ENG-SF21021-R1-FDR.pdf Markup Summary

Subject: EPC ENG Review
Page Index: 1
Date: 7/6/2021 8:29:53 PM
Author: dsdrice
Color: ■
Layer:
Space:
Page Label: 1

EX Channel Sand Creek CL

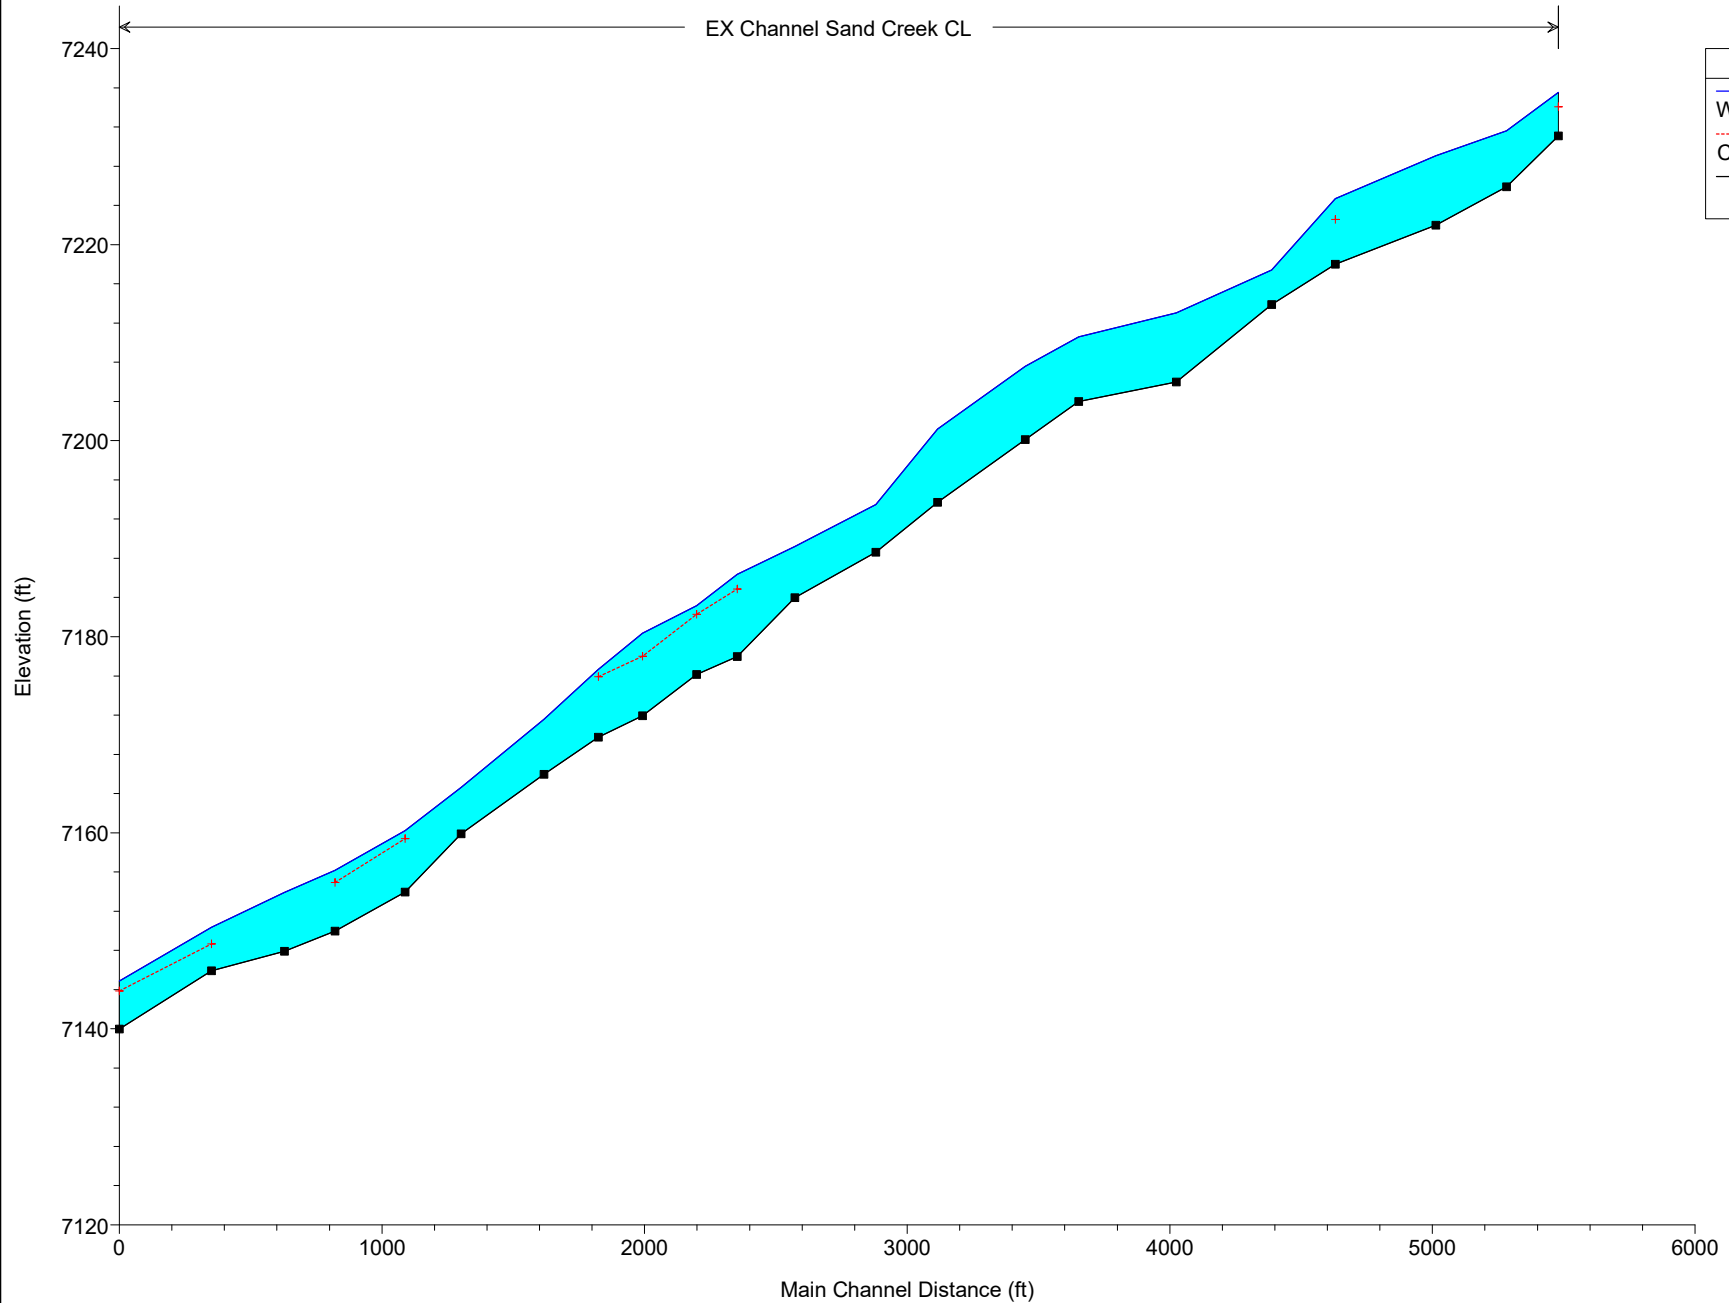
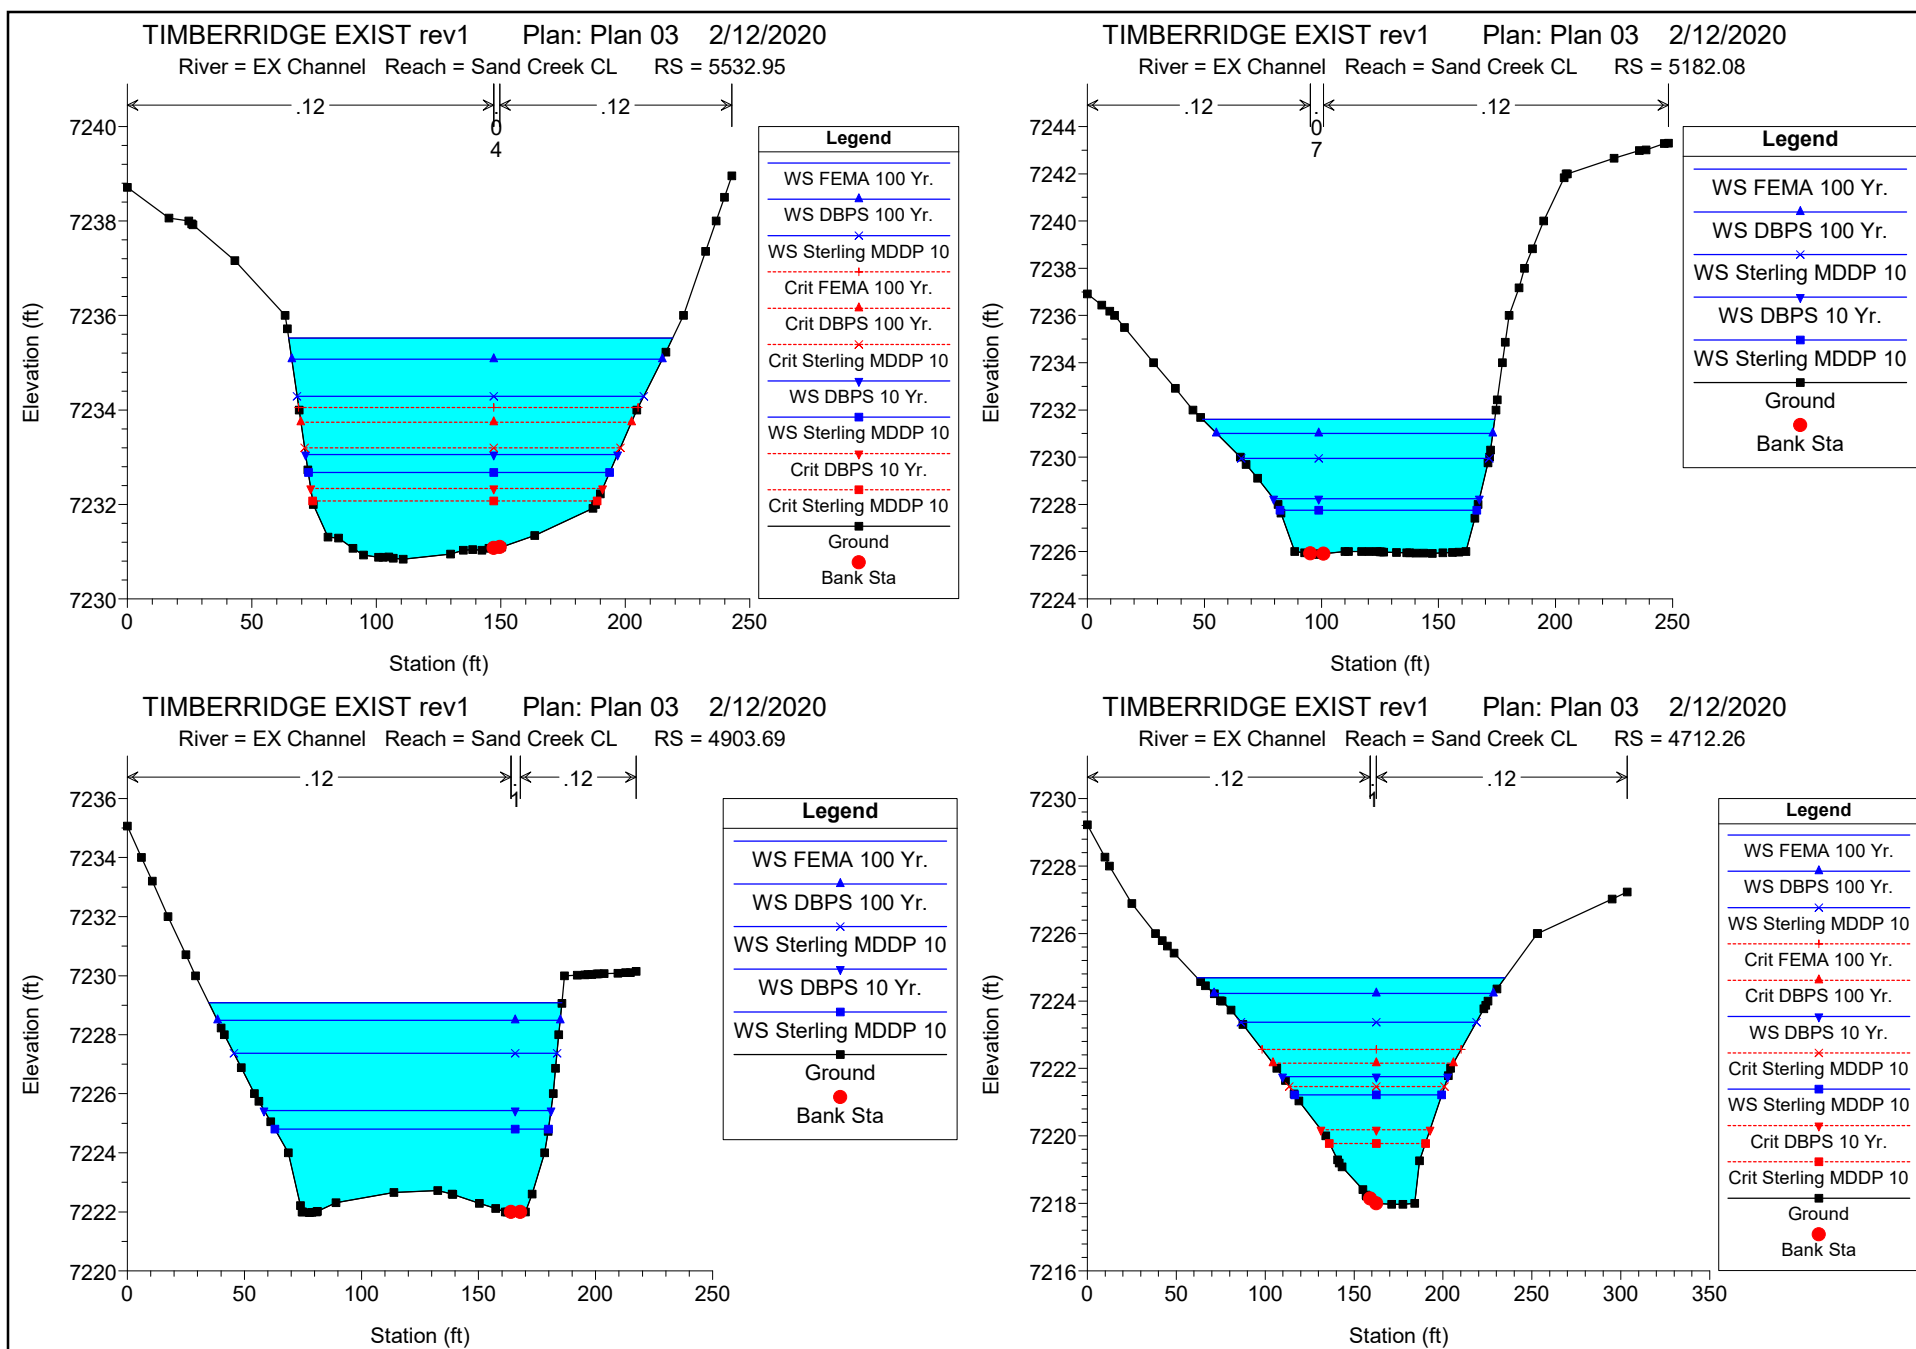
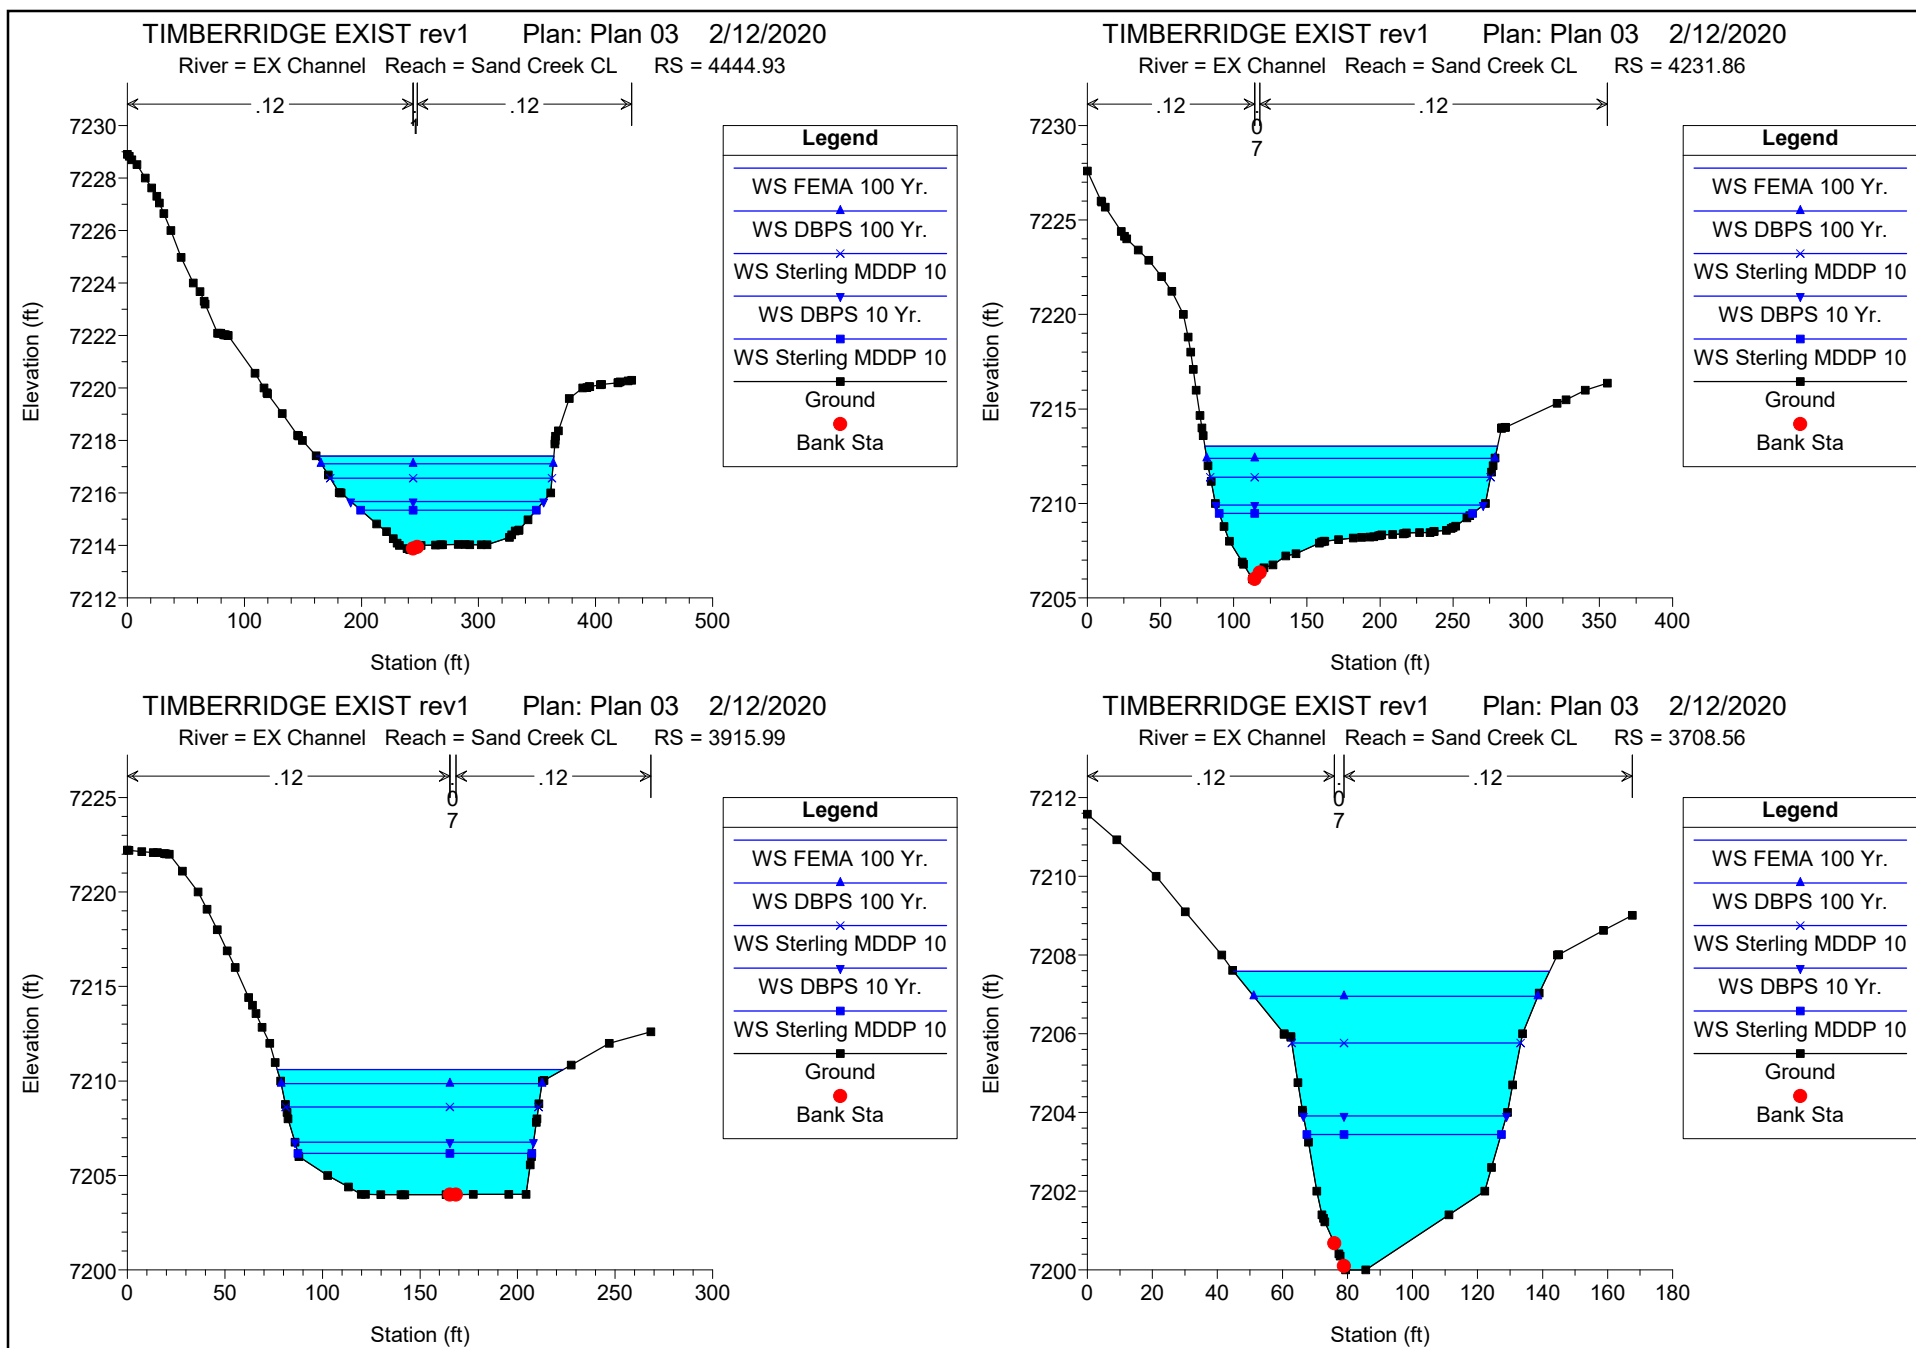
Please highlight the cross-sections within and adjacent to this plat.
